Date: 16 August 2021

Application by Net Zero Teesside Power Limited and Net Zero North Sea Storage Limited for an Order granting Development Consent for the Net Zero Teesside project

Advice following issue of decision to accept the application for Examination

Figure 17-7a **DATE**

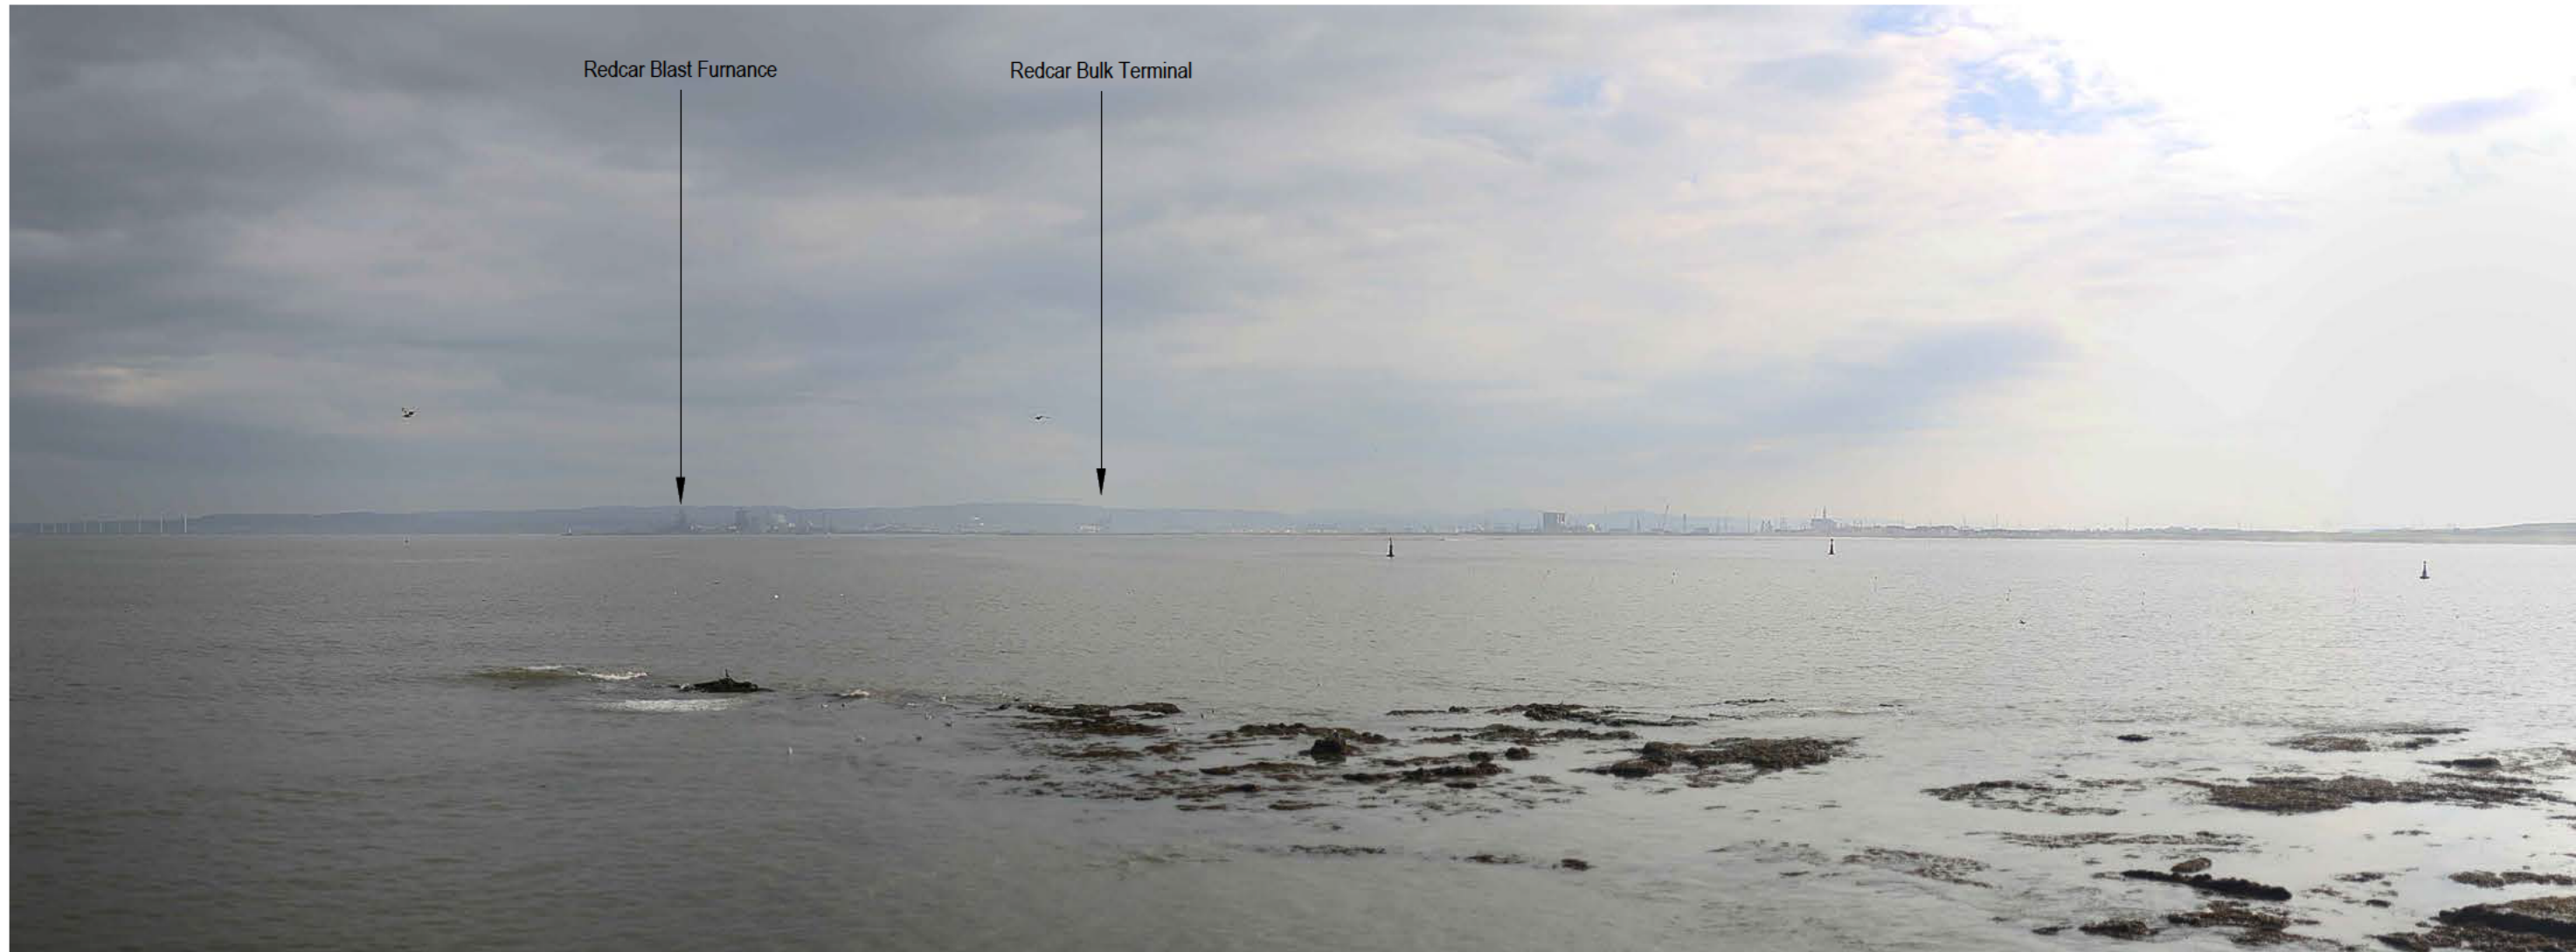
The following documents are corrupt, the Applicant is requested to provide amended versions;

- 6.3.74 ES Vol II Figure 17-7a Viewpoint 1 – Albion Terrace Hartlepool (Summer).
- 5.2 Project Need Statement.
- 5.11 Indicative Lighting Strategy.
